Our ref: HA/2022/123851/01-L01
Your ref: LU/369/21/RES
Date: 24 January 2022

**APPROVAL OF RESERVED MATTERS FOLLOWING OUTLINE CONSENT
LU/47/11/ (AMENDED UNDER LU/182/15/PL) FOR THE FORMATION OF THE
CENTRAL WETLAND AREA AND THE CONSTRUCTION OF THE CENTRAL SPINE
ROAD RUNNING ACROSS THE CENTRAL WETLAND AREA, LINKING UP PHASE
5 AND PHASE 2B (ALSO KNOWN AS PHASE 4). CENTRAL WETLAND AREA
HAMPTON PARK TODDINGTON LANE LITTLEHAMPTON BN17 7PL**

Environment Agency Position

FLOOD COMPENSATION

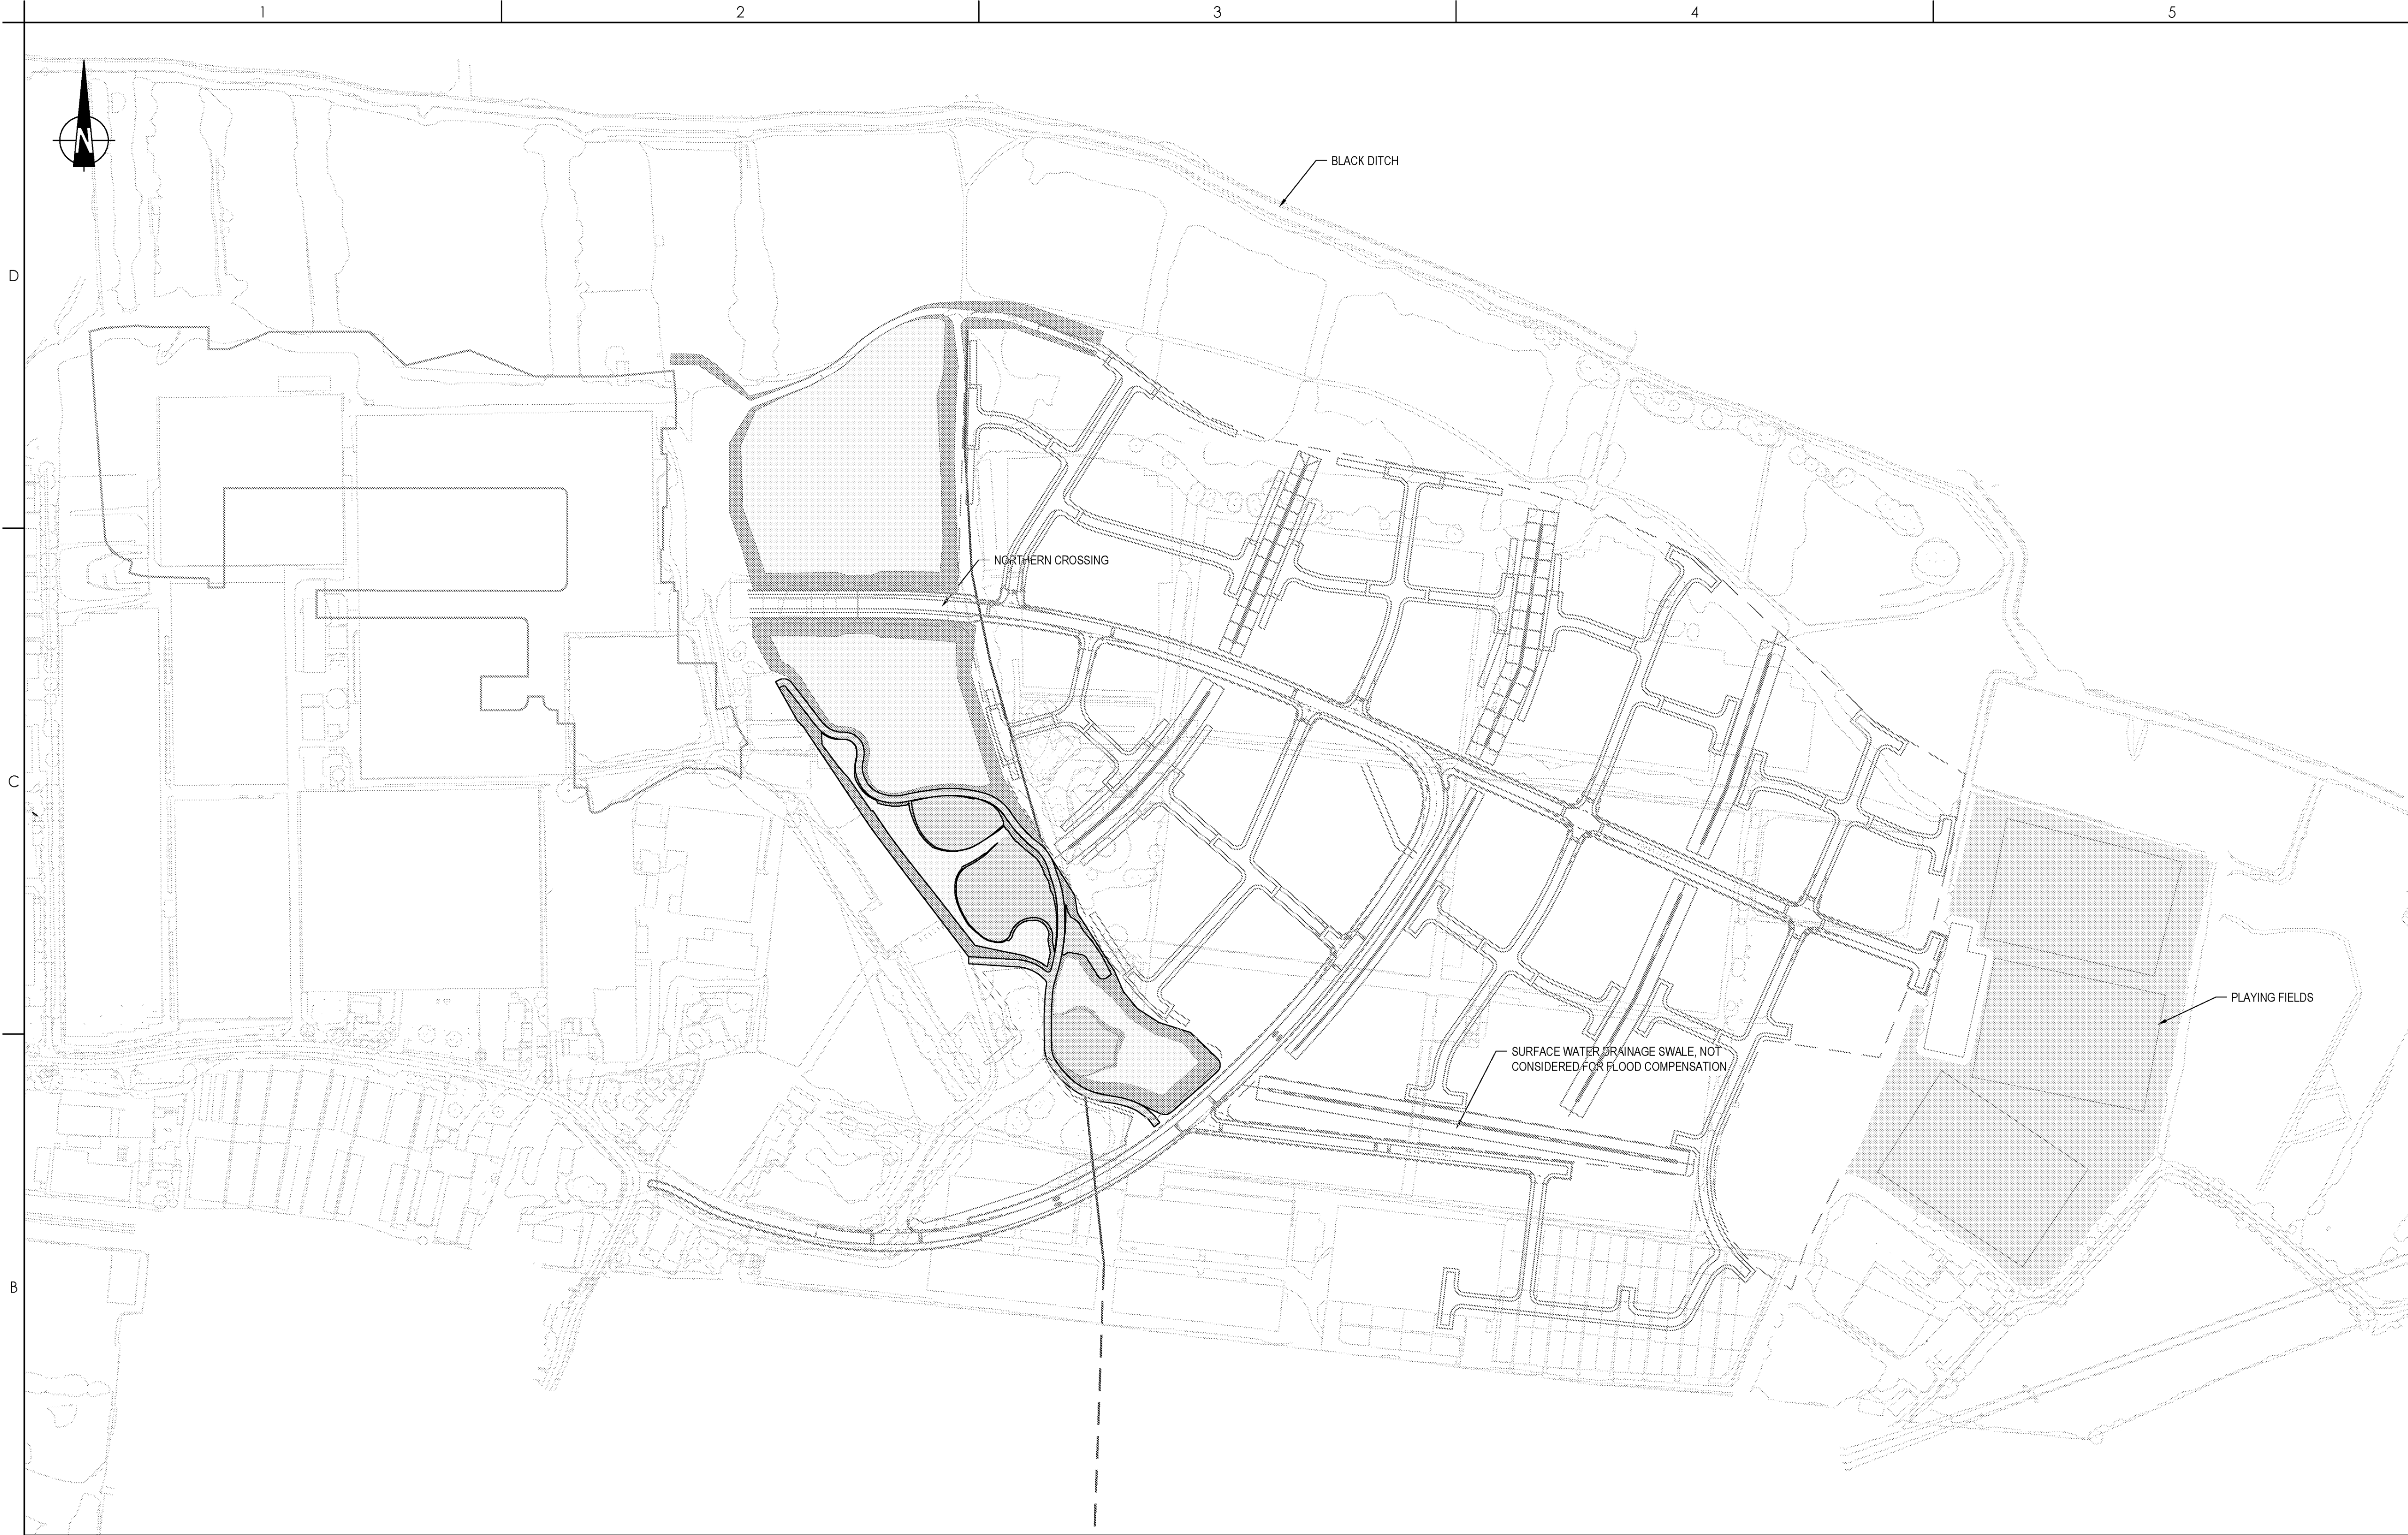
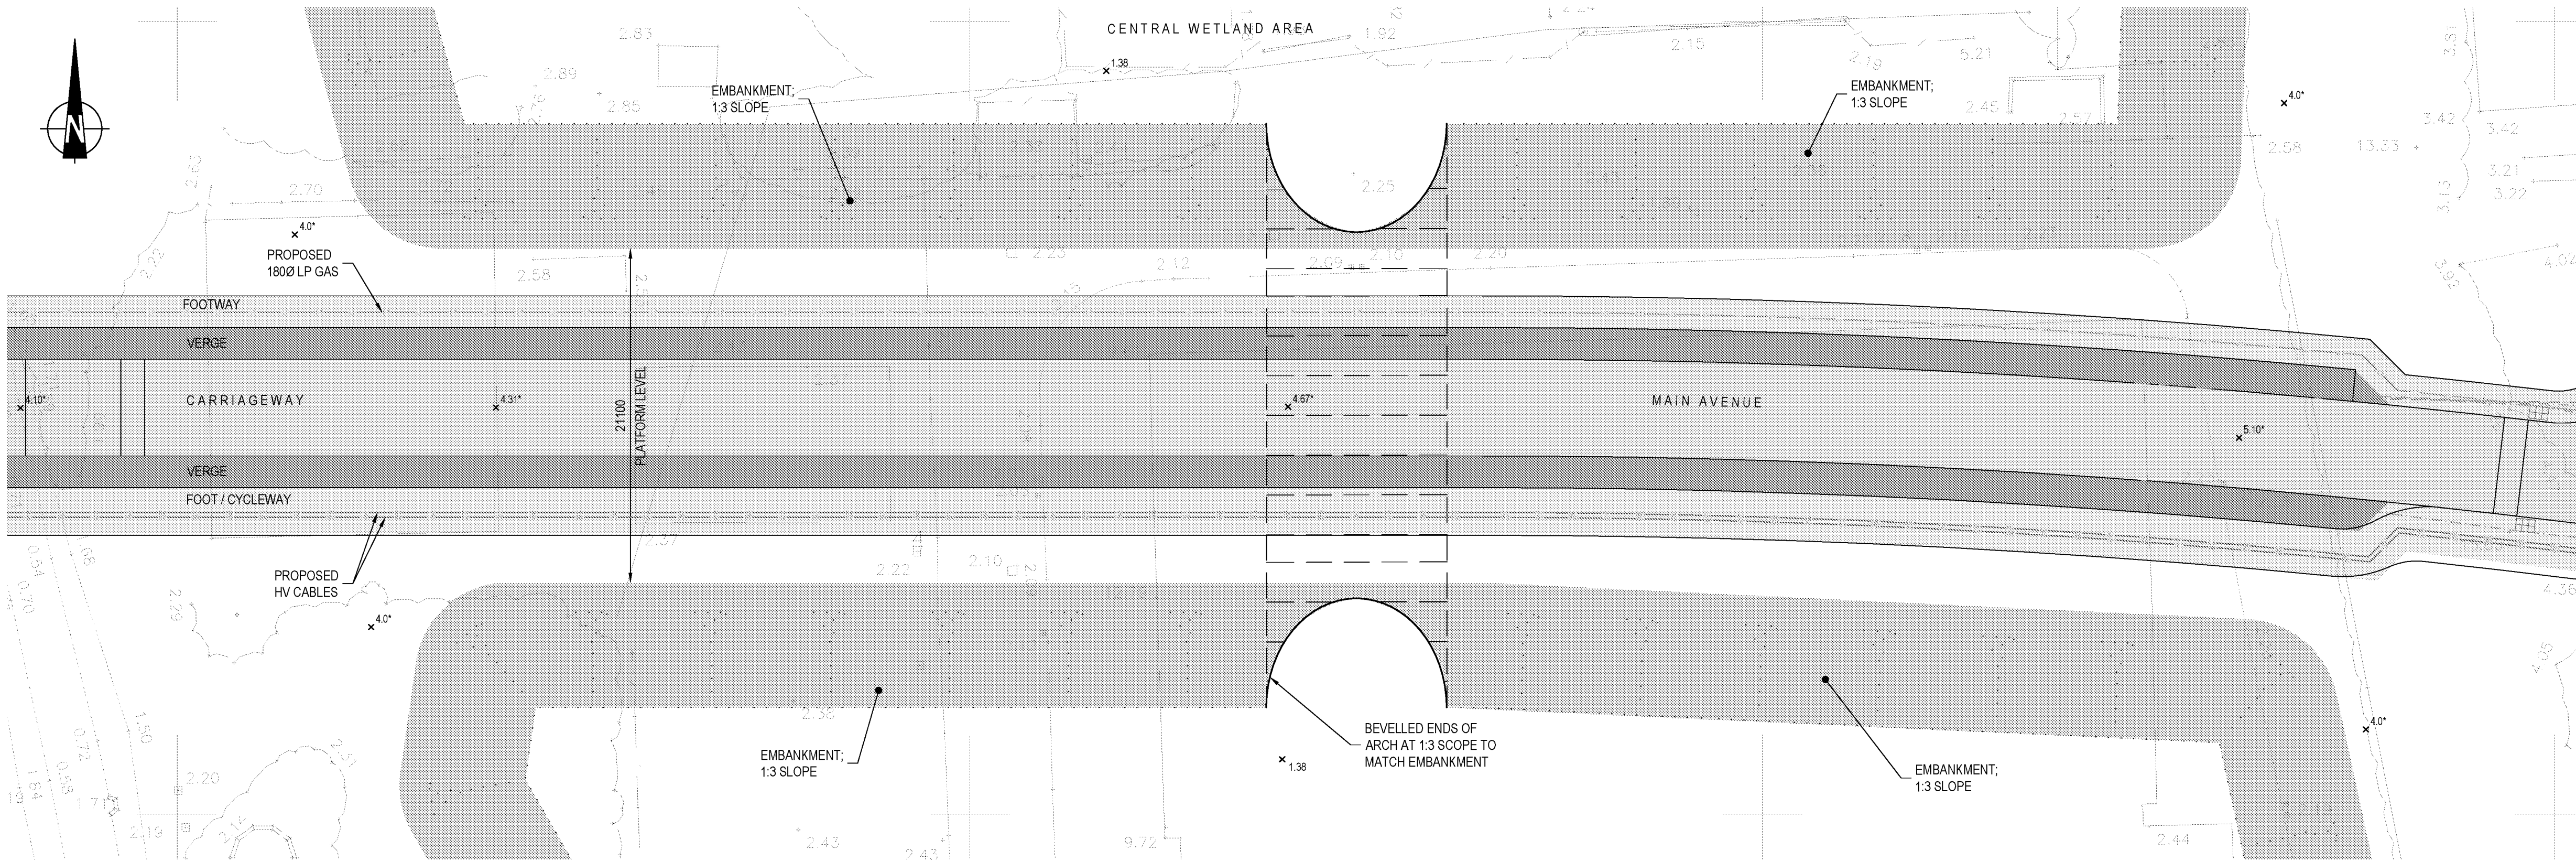
- The defended 0.1% AEP flood level has been used to calculate flood plain compensation, instead of the undefended level, which is best practice; especially considering the modelling used is over 10 years old and no additional modelling has been undertaken to establish the impacts of climate change. We would therefore request to use the undefended 0.1% AEP flood level of 2.90m AOD for the flood plain compensation calculations.

- The flood plain compensation proposed with this planning application will only create 324m³ additional storage, which is considerably lower than the 27,300m³ proposed at the outline planning application, which was one of the reasons of the removal of the Environment Agency(EA) initial objection.

- It looks like the majority of the compensatory storage area is within Flood Zones 2 and 3. This is an inappropriate location for a compensatory storage area as this land would be expected to flood in the design event. Digging down into this land would not provide the designed compensation volume as the soil would be saturated and area would be expected to fill with water anyway. Compensatory storage areas should be providing flood storage outside of design flood extent.

- The calculations provided in table 1 of the Technical Note show loss of storage at the lower and higher levels. To be an acceptable compensation scheme, the volume of flood gained in each particular slice should be greater than the volume lost for that same slice.

- The compensation area should be completely free filling and draining and should not use culverted or piped entry routes. This is to ensure the compensation area can fill and drain under gravity and so will be available should back to back flood events occur. It is not clear how the proposed flood compensation area will fill and drain.

To overcome our objection, the applicant should submit a revised FRA which addresses the points highlighted above.
